From: Simon Davis
Sent: 19 March 2020 16:13
To: Ellie White [REDACTED]
Subject: RE: Y/18/20/PL - East of North End Road and West of Church Lane Nursery

From: Ellie White [REDACTED]
Sent: 18 March 2020 11:08
To: Simon Davis <Simon.Davis@arun.gov.uk>
Subject: RE: Y/18/20/PL - East of North End Road and West of Church Lane Nursery

From: Simon Davis <Simon.Davis@arun.gov.uk>
Sent: 17 March 2020 10:25
To: Ellie White [REDACTED]
Subject: RE: Y/18/20/PL - East of North End Road and West of Church Lane Nursery

4 BEDROOM
SIDE ELEVATION - West
Detached House
Plot 1

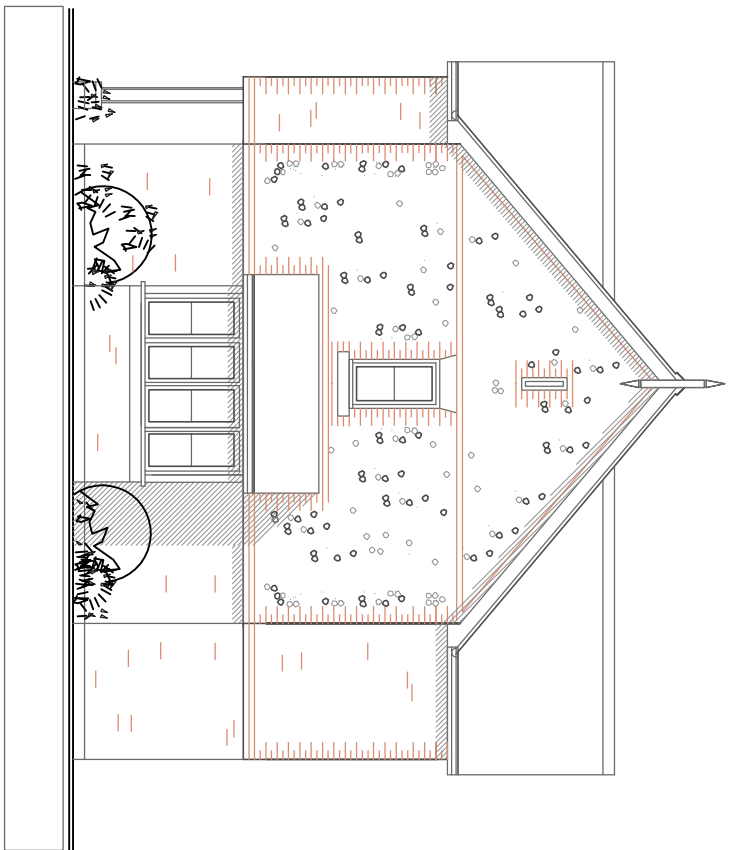
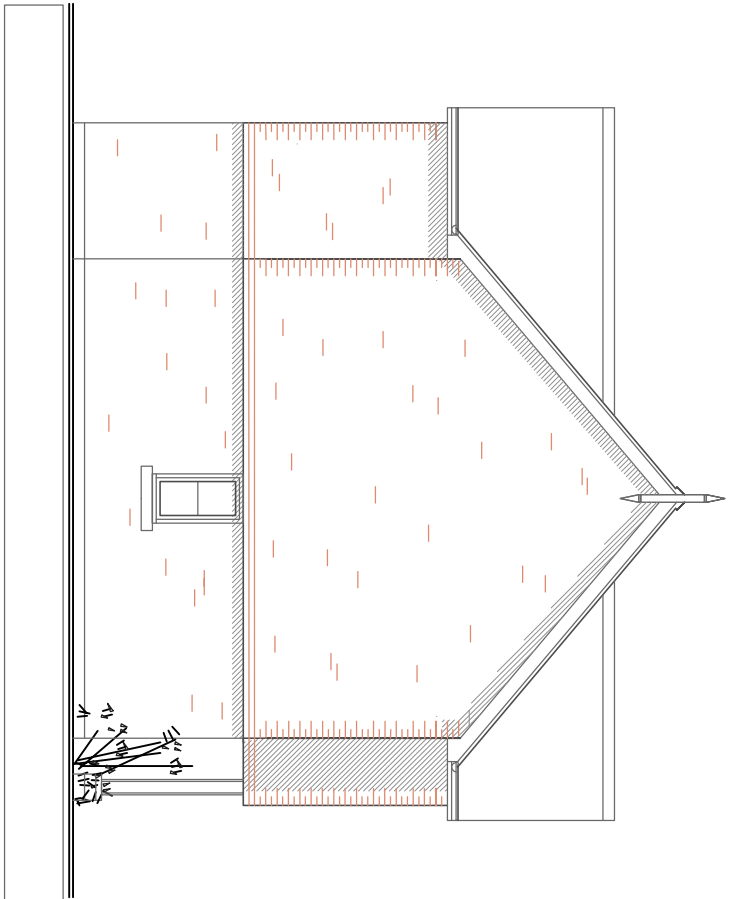
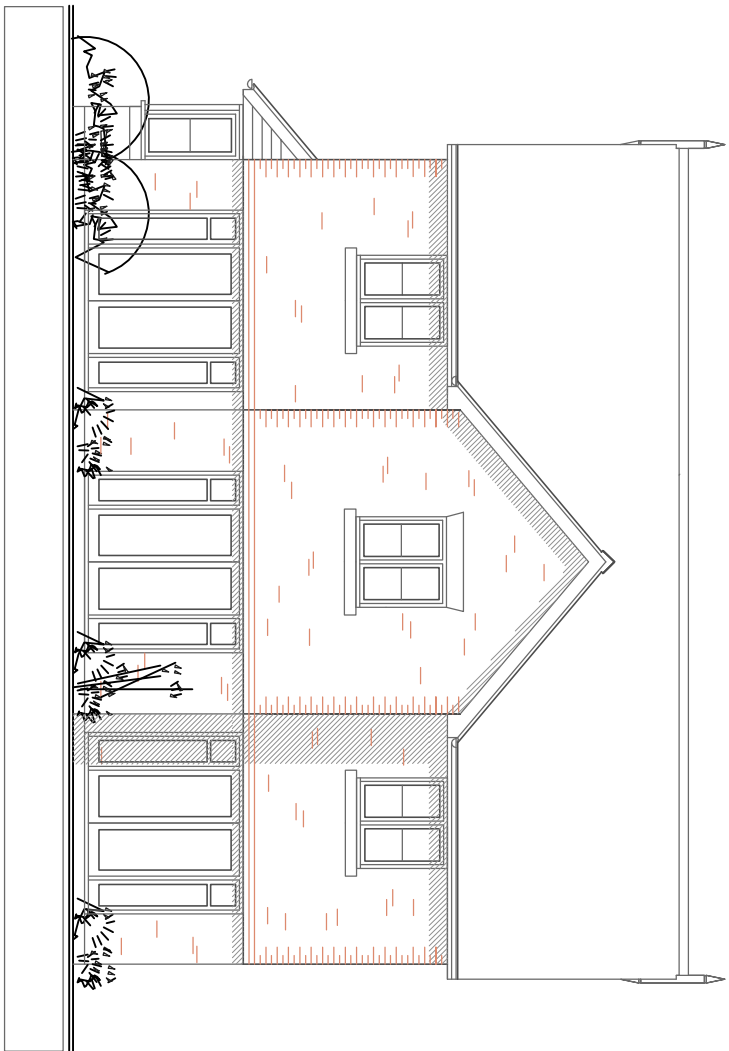
I must admit that when I read the YPC comments, I read their point about building height as being that they wanted plot 1 to be single storey. If I'd have read it right in the first place, I wouldn't have sought your view on it!

- *Plot 1 not to exceed 2 storeys in height to maintain and enhance the mixed street scape of North End Road.*
- *The developer to protect the existing wide grassed verge fronting North End Road and extending to Church Lane by installing small 0.5m high bollards to prevent verge side parking. This will ensure the safety of any pedestrians using the pavement and the protection of the grass verge. YPC note that WSCC have recently released a statement confirming that they will not be replacing bollards such as the ones missing along this stretch of verge leaving residents and the Parish with the responsibility of finding a solution. YPC see this condition as forming an appropriate solution.*

In terms of plot 1, we have obviously submitted a detailed application with clear site, elevation and floor plans. These plans clearly demonstrate that plot 1 is a 4 bed dwelling and the applicant has no interest in exceeding two storeys in height. The applicant is happy for the elevations for this plot to be conditioned; although I imagine you would usually look to do this anyway? This would then secure the two storey element with approval needed to amend.
